Aditi Coomar
Department of Planning & Environment
320 Pitt Street
SYDNEY NSW 2000

Your Ref: SSD 7919
Council Ref: DA371/17
(KRR) (CIS)

RE: REDEVELOPMENT OF LORETO SCHOOL (MASTERPLAN, STAGE 1 AND CONCEPT STAGE 2 AND 3)

title
**Envelopes
Site Plan - Proposed Envelopes Final
Phase**

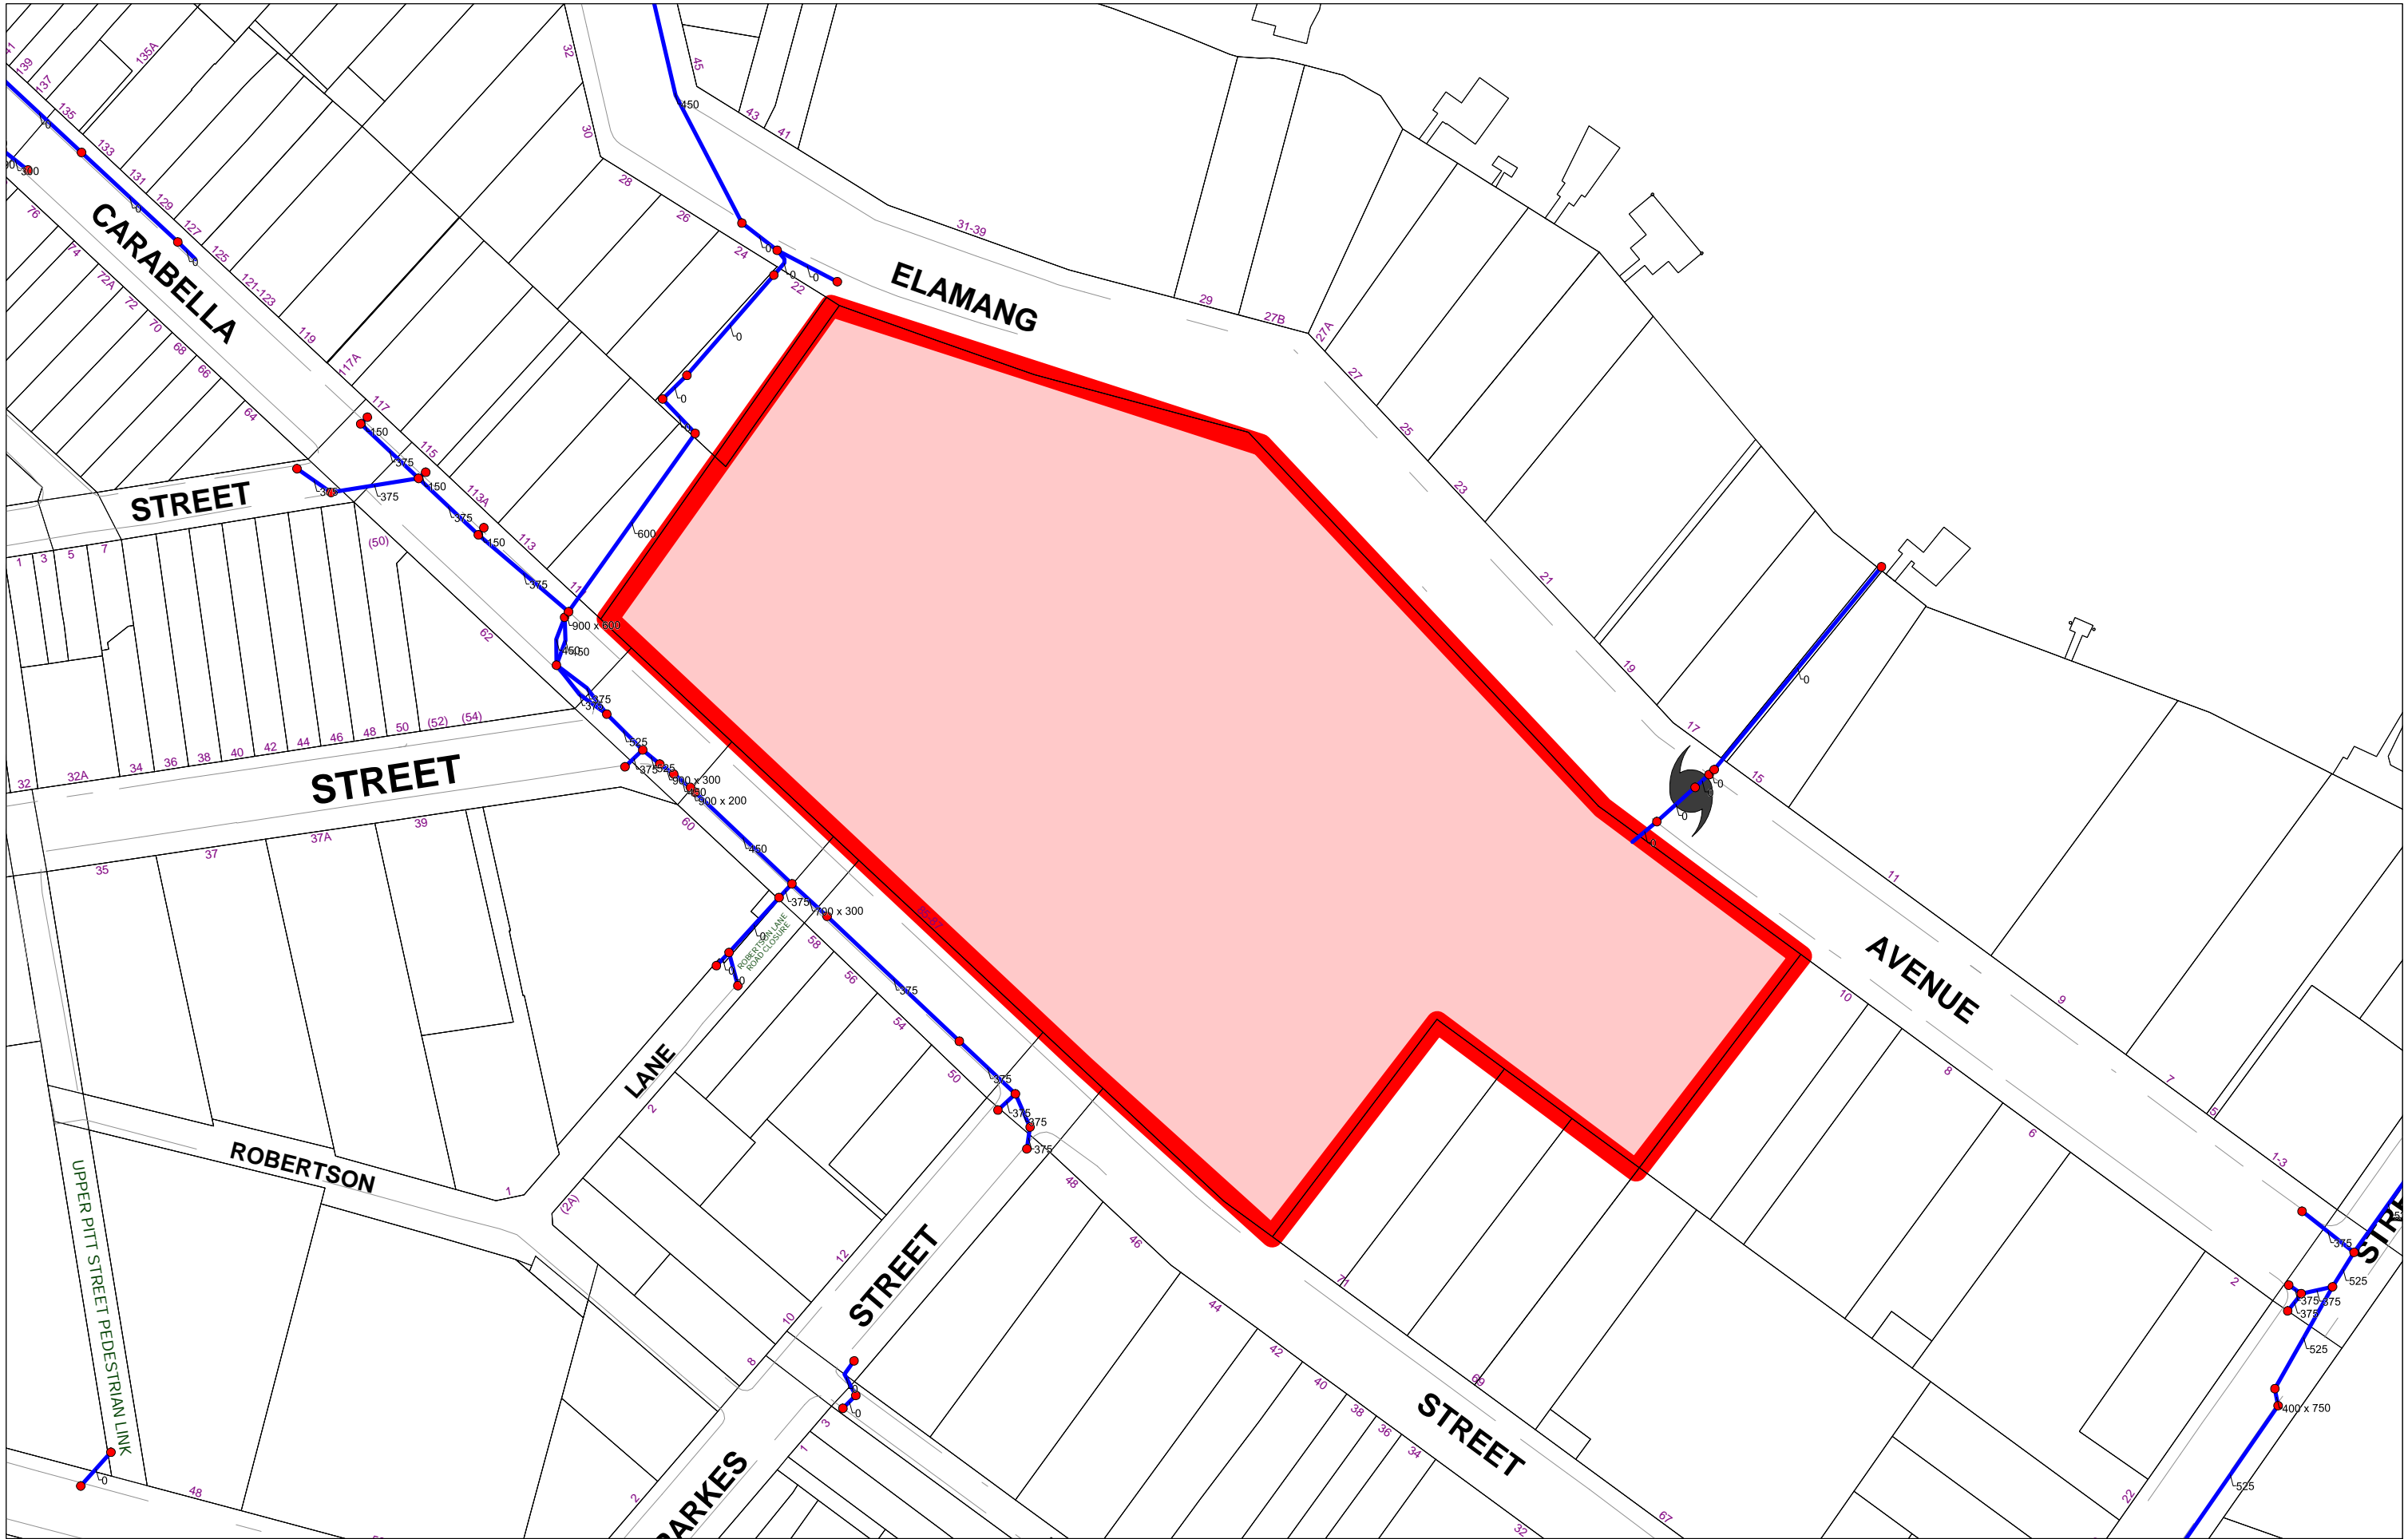
Clause 4.3(3) of NSLEP 2013 states that the maximum permitted building height on the site is 12 meters over the portion of the site which is zoned R4 High Density Residential. The works of most significance in the Stage 1 Western Precinct include the 7 story learning hub and an overall height of 14.5 metres exceeding the height limits for this zoning (12 metres).

North Sydney Council is of the view that the scale of the New Buildings particularly the new additions to the western building (Learning hub) located close to the adjoining boundary site are incompatible with the sites adjoining and opposite along Carabella Street and Elamang Avenue. Existing buildings at the eastern end of the sites are zoned R2 Low Density Residential with a maximum permissible building heights of 8.5 m (**refer to Figures 1 and 2 below**).

The height and depth of the building is such that the new Learning hub building will significantly impact upon the eastern outlook currently afforded from 111 Carabella Street residential dwellings.

The new works to the new Learning hub in Stage 1 of the proposal propose a new rooftop recreation area can introduce amenity impacts such as overlooking and privacy impacts. The height, depth and proximity of the new Learning hub to the Marian Centre will also significantly reduce solar amenity to the Marian Centre and adjoining residential properties to the west.

Concern is raised that there will be loss of views to high amenity water views currently afforded from the eastern outlook from 111 Carabella Street, Kirribilli. A reduction to the height and depth to the building can ameliorate the potential impact.

The proximity to the boundary of the new Learning Hub building inclusive of the overall height of the building. The depth of the building is such that shadowing to 111 Carabella Street will be expanded and extended to being to cover the north eastern elevation of the building and further reduce available solar access.

The proposed extended Learning Hub (Stage 1) has between a minimal side setback to the western boundary of the site which is considered insufficient for a building of this scale and does not provide for adequate building separation with the existing townhouse development at No's 22 Elamang Avenue and 111 Carabella Street.

A greater building setback to this western boundary should be provided with additional deep soil landscaping and minimize the visual (bulk and scale) and privacy impact of the new learning hub building to this adjoining property.

Privacy concerns are raised regarding the lower levels of the new Learning Hub at the western end of the site and the view and noise corridor created as a result of the orientation of and depth below ground level of the lower levels of the hub towards the existing residential flat building at 22 Elamang Avenue, Kirribilli.

Additionally, the new Learning Hub building proposes a new rooftop activity area. Any use of this area should be restricted to ensure there are no adverse noise or visual privacy impacts occurring from this new roof area.
